Date: 12 April 2017

**SECTION 75W REQUEST TO MODIFY THE MINISTER'S APPROVAL OF
PROJECT APPLICATION 06_0250 (28 JUNE 2010) – NELSON BAY ROAD,
FERN BAY.**

MODIFICATION 9 (MP06_250 MOD9) – RESPONSE TO SUBMISSIONS.

SCALE	1: 1000	DRAWING TITLE	STAGES 18 & 19 DETAIL PLAN REV L
REVISION DATE	01/11/2016	DEVELOPMENT	PROJECT PLAN L
PLOT DATE	01/11/2016	DRAWN/CHKD BY	FERM BAY SEASIDE VILLAGE
DA NUMBER		IMC / AED	NELSON BAY ROAD, FERN BAY
		CC NUMBER	CLIENT
			RAWSON COMMUNITIES PTY LIMITED

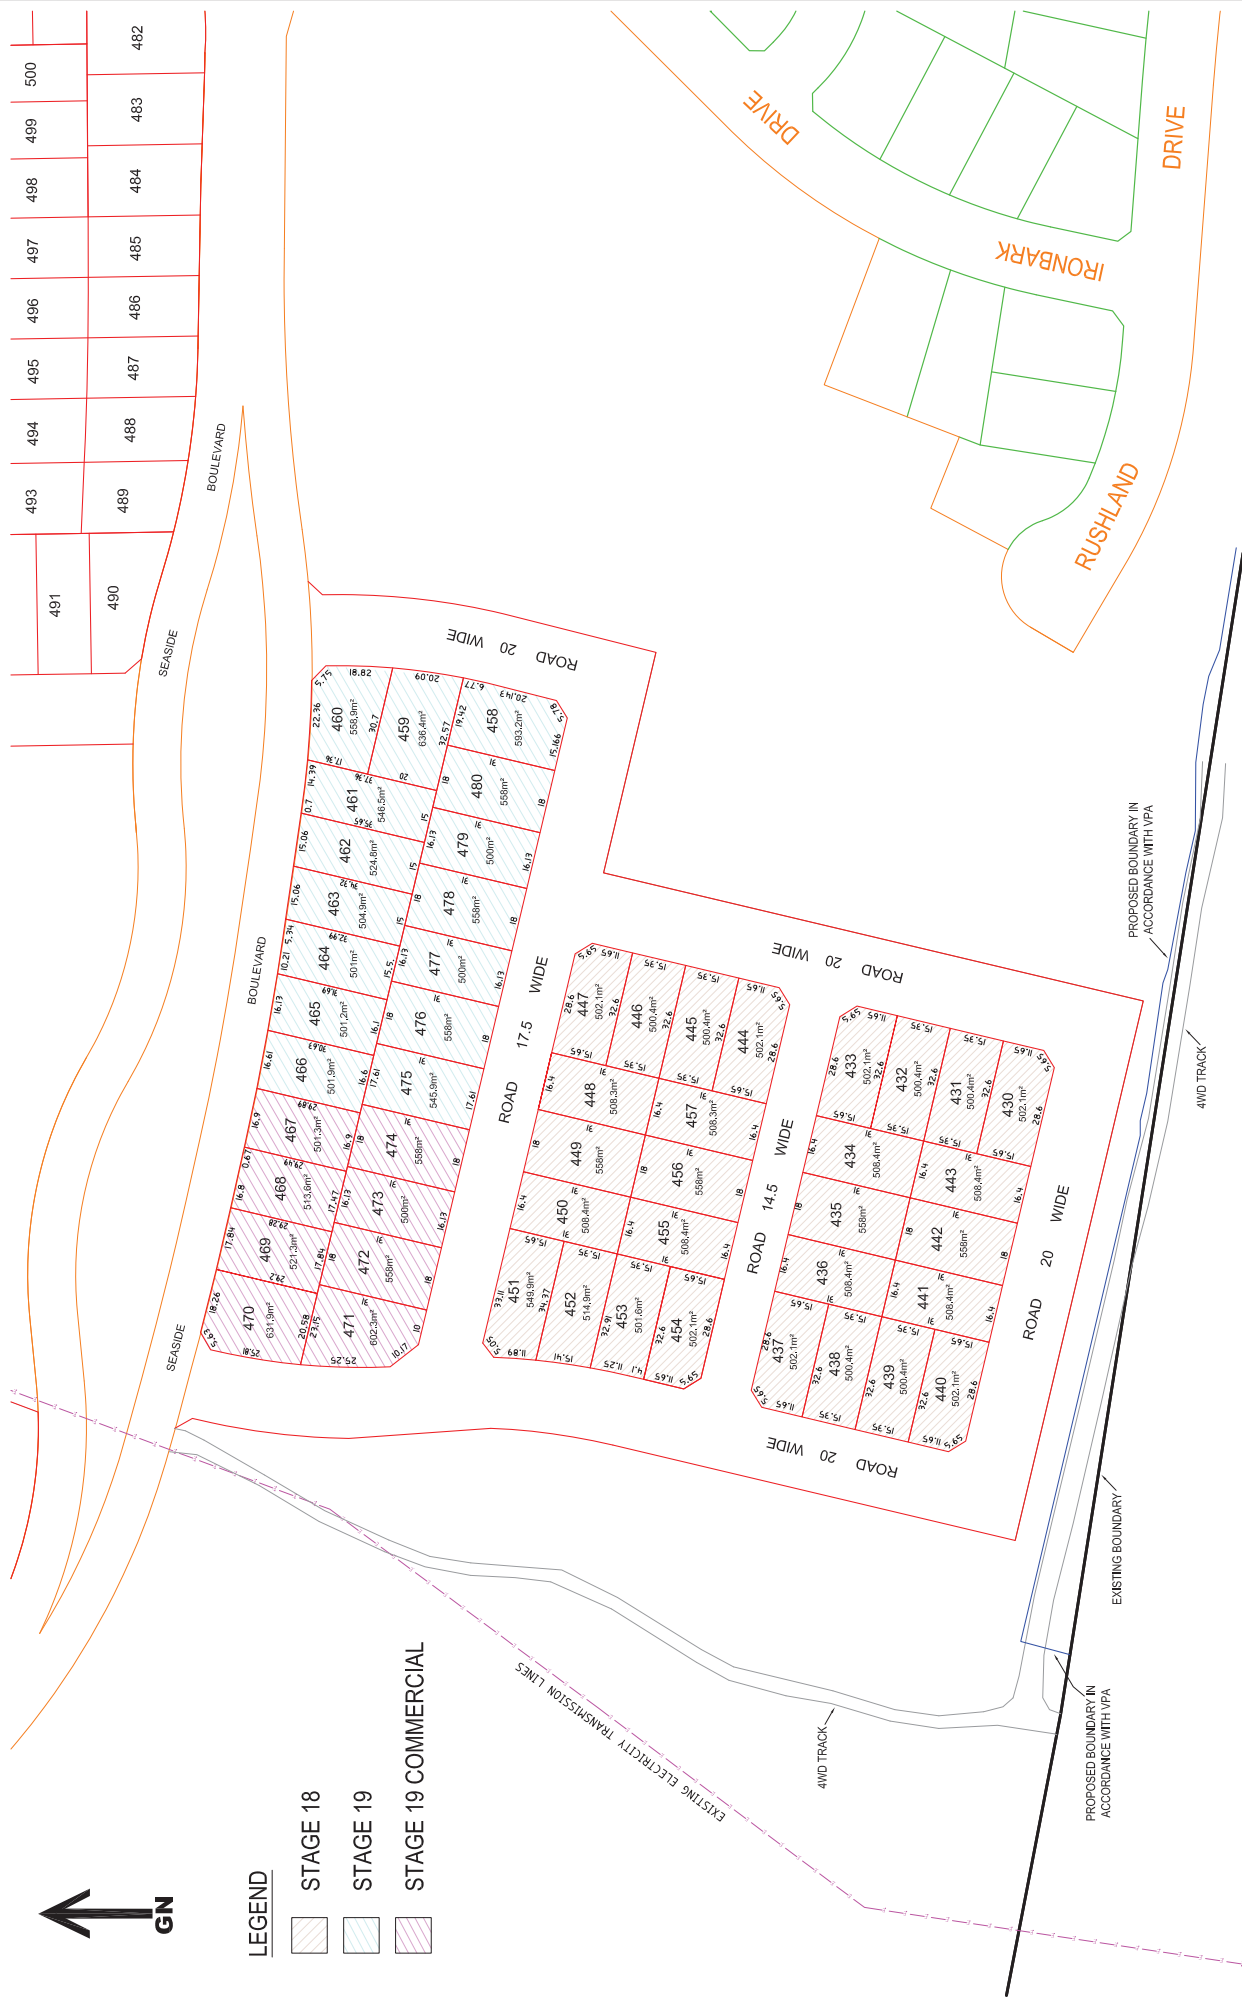
Concern was raised that the proposed drainage / conveyance swale to the west from Stage 18 & 19 extends across the existing 4WD track with the risk that stormwater may cause scouring of the track.

Response: Rawson Communities have agreed to convey stormwater in a culvert below the 4WD track to avoid stormwater damage. This requirement can be conditioned to be satisfied prior to issue of a subdivision certificate for Stage 18.

14 OF 21

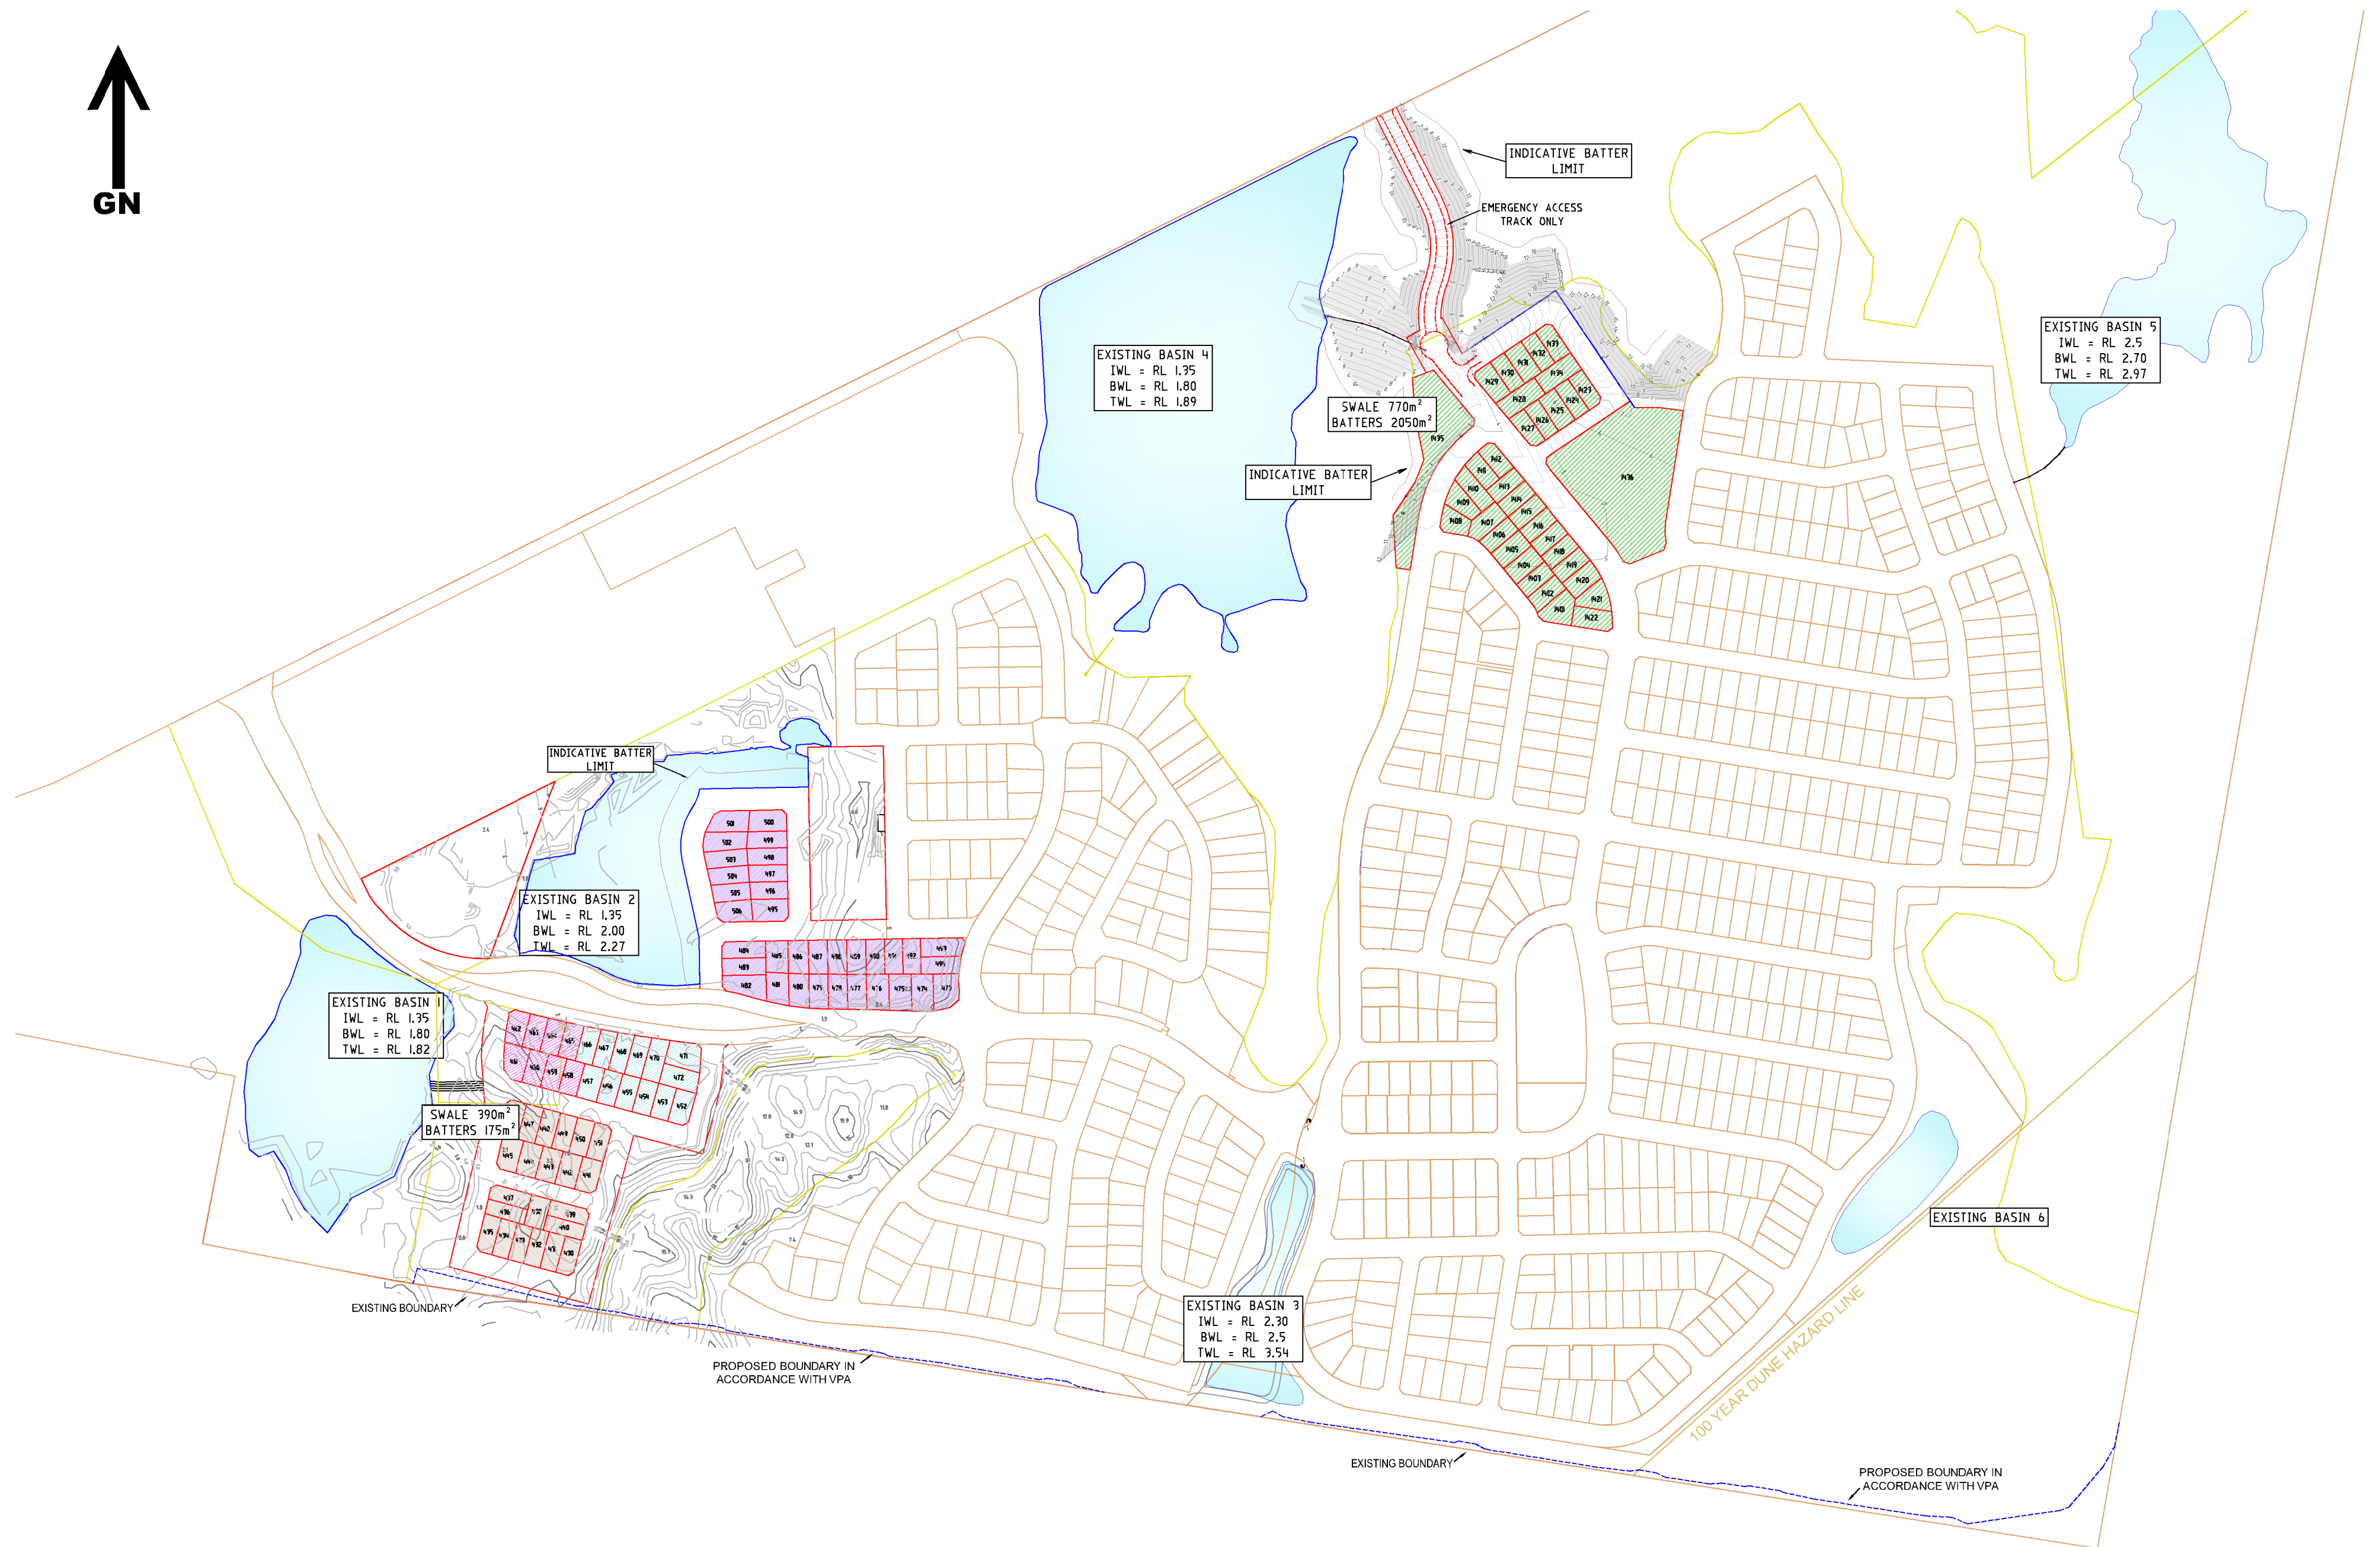
Concern that the stormwater system has failed in the past in heavy rain events resulting in discharge into the WCL and erosion of the 4WD track, and that there is potential for this situation to reoccur. OEH expresses reservations about the level of information provided with the Modification Application and is concerned that the information is insufficient to determine the effect of the development on the VPA commitments for 4WD access to the WCL.

Response: Stormwater for the whole development is to be managed in accordance with the approved Water Cycle Management Strategy prepared by Marten's for Major Project 06_250.

The Marten's Report modelled the Top Water Level adjacent to Stage 18 and 19 (refer to project plans Rev L accompanying Modification 9 on Sheet 14) and determined as 1.82m AHD. It is noted the existing level of the access track on the western side of Stages 18&19 at its lowest point adjacent to the proposed swale is 2.6m AHD. Given the top water level is well below the existing 4WD track access level, the track for access to WCL will not be subjected to stormwater flows as a result of the proposed modification. Stormwater flows from the subdivision on the southern boundary of Stages 18&19 are to be captured and conveyed to the approved existing Basin 1, in accordance with the approved Water Cycle Management Strategy. As outlined in Section 3.4, a culvert will be designed and constructed to ensure flows do not impact on the existing 4WD access track or access to the WCL. In addition the proposed modification does not impact on any commitments of the VPA.

PROPOSED RETAINING WALL

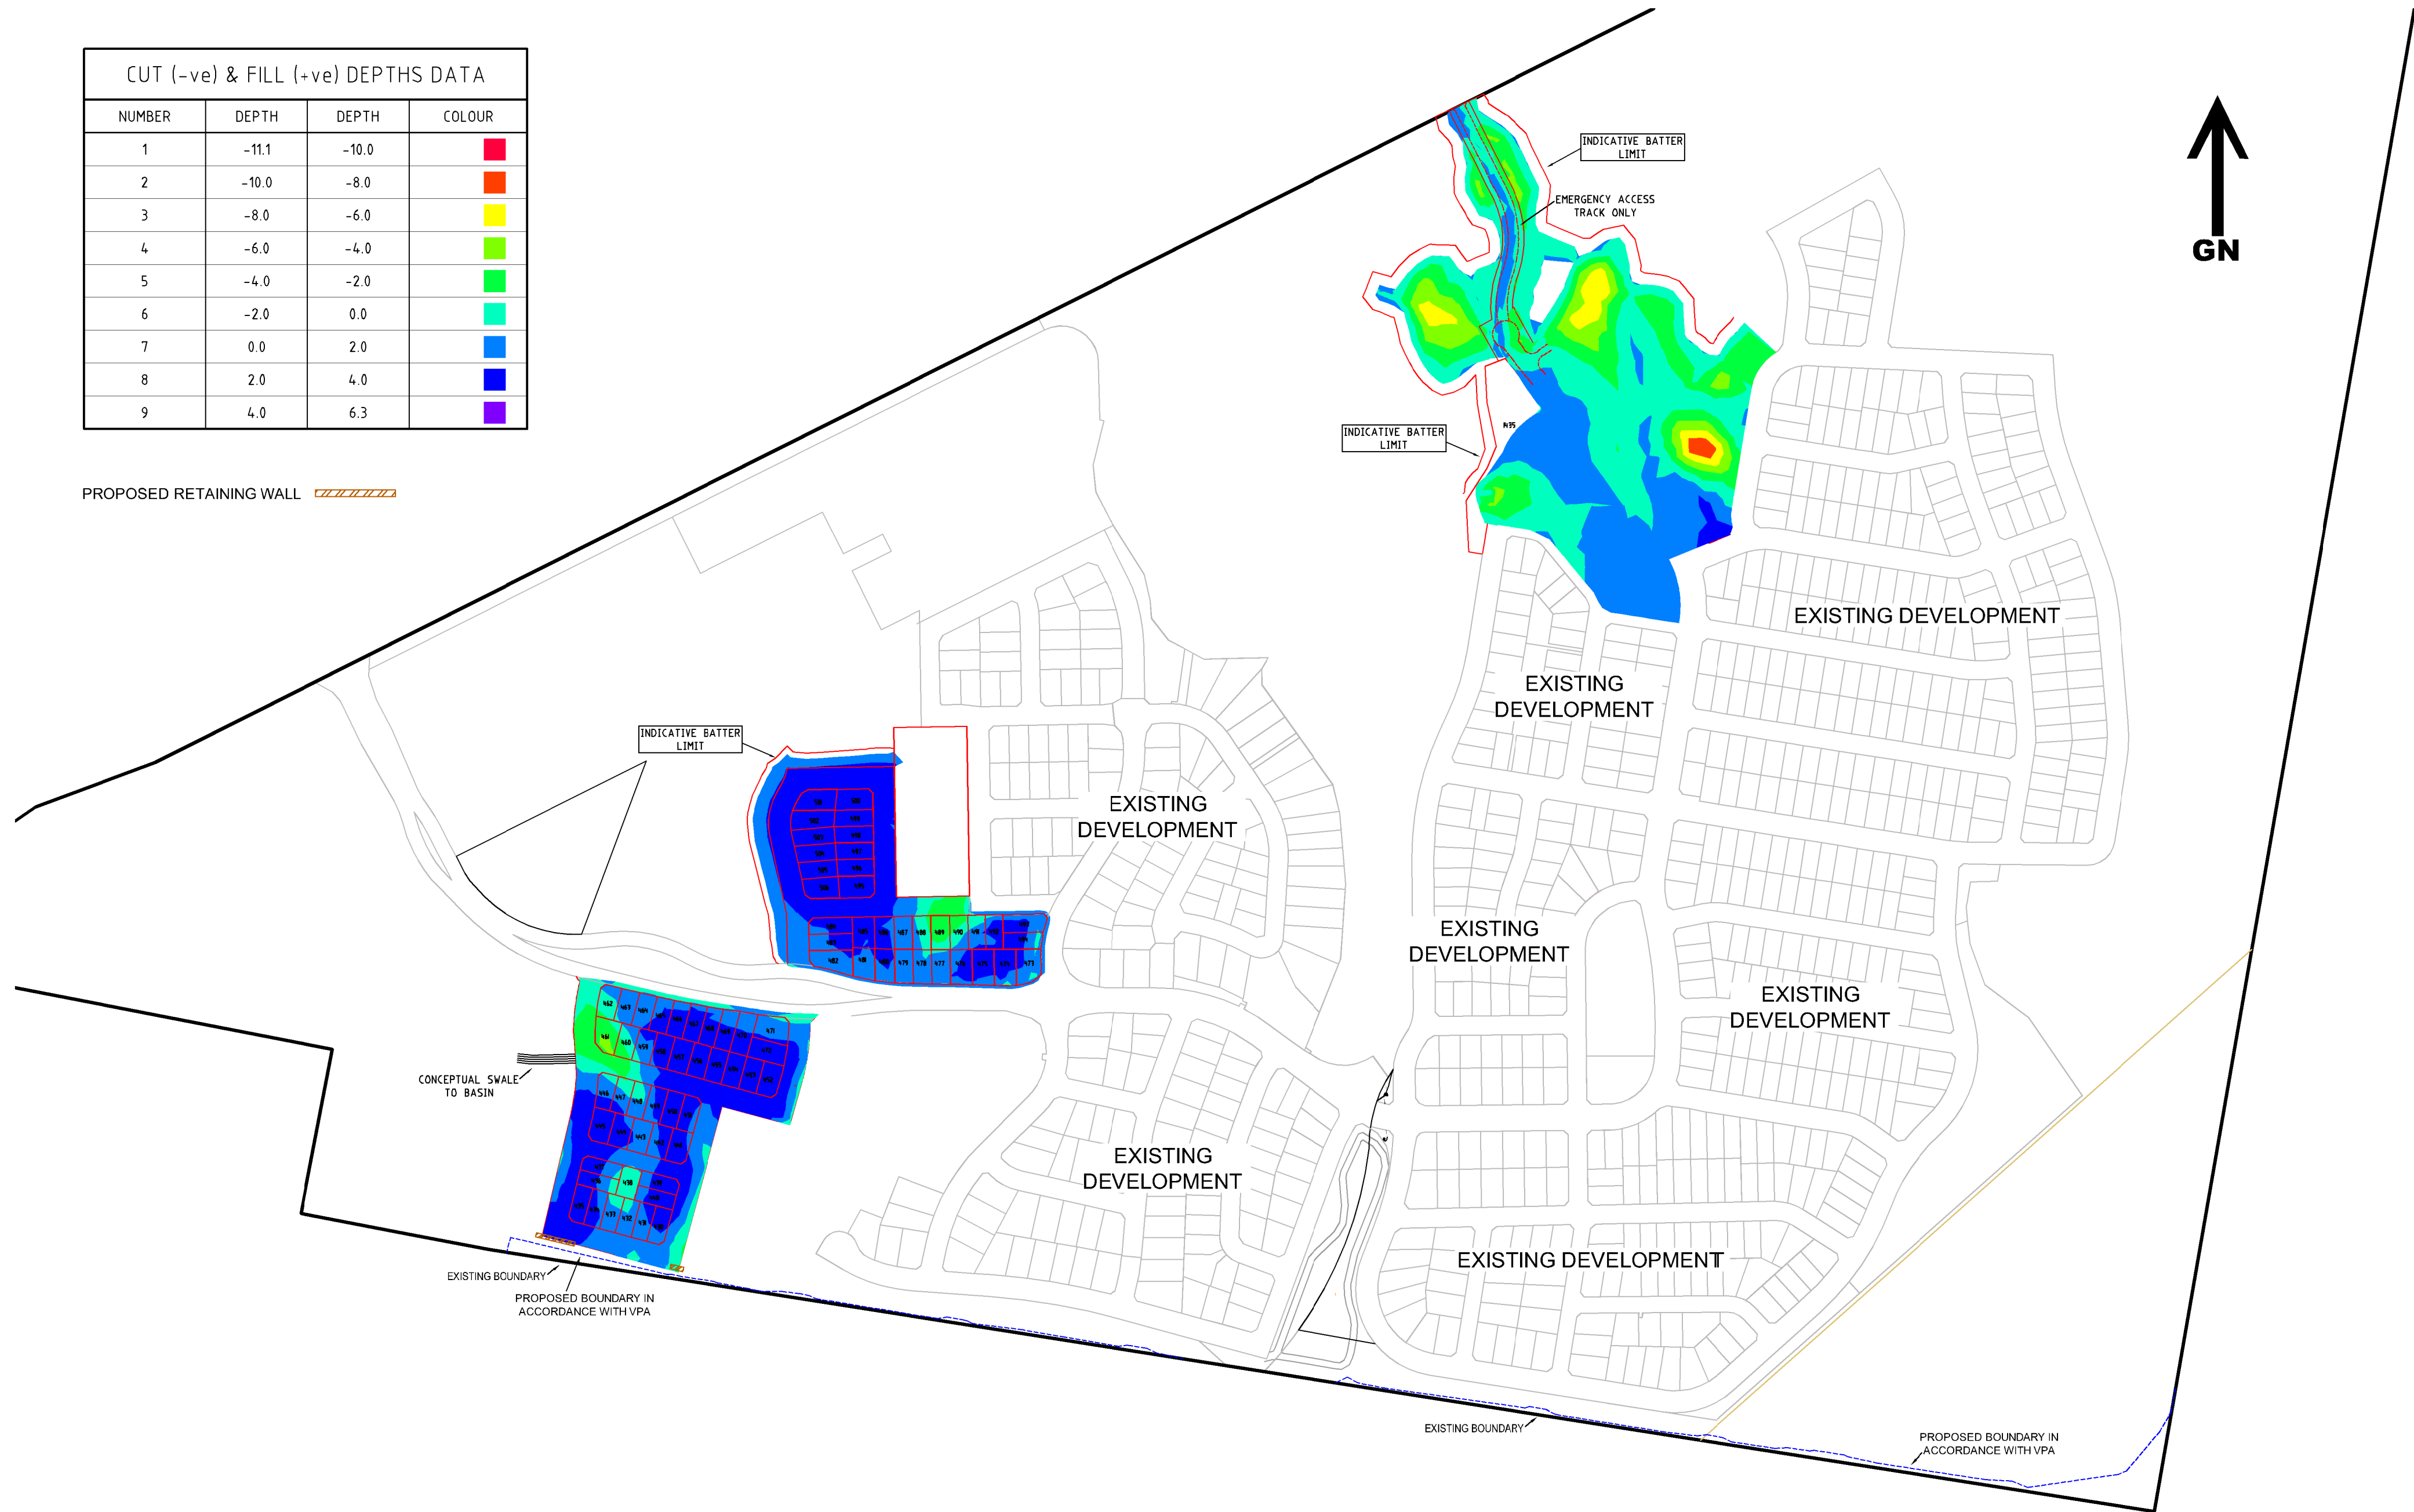
Concern raised that the proposed retaining walling at the southern edge of the Development may encroach onto the WCL and may impact on the 4WD track.

Response: To address any potential impacts of the retaining walling on the integrity of the WCL or the 4WD track, the Proponent agrees to comply with a condition applied to the determination of the Modification Application to that effect. The retaining wall will be constructed within the boundary of the development with no disturbance of land to occur on the WCL, either during or after the construction process. Any land required for maintenance of the retaining wall will also be contained within the development site.
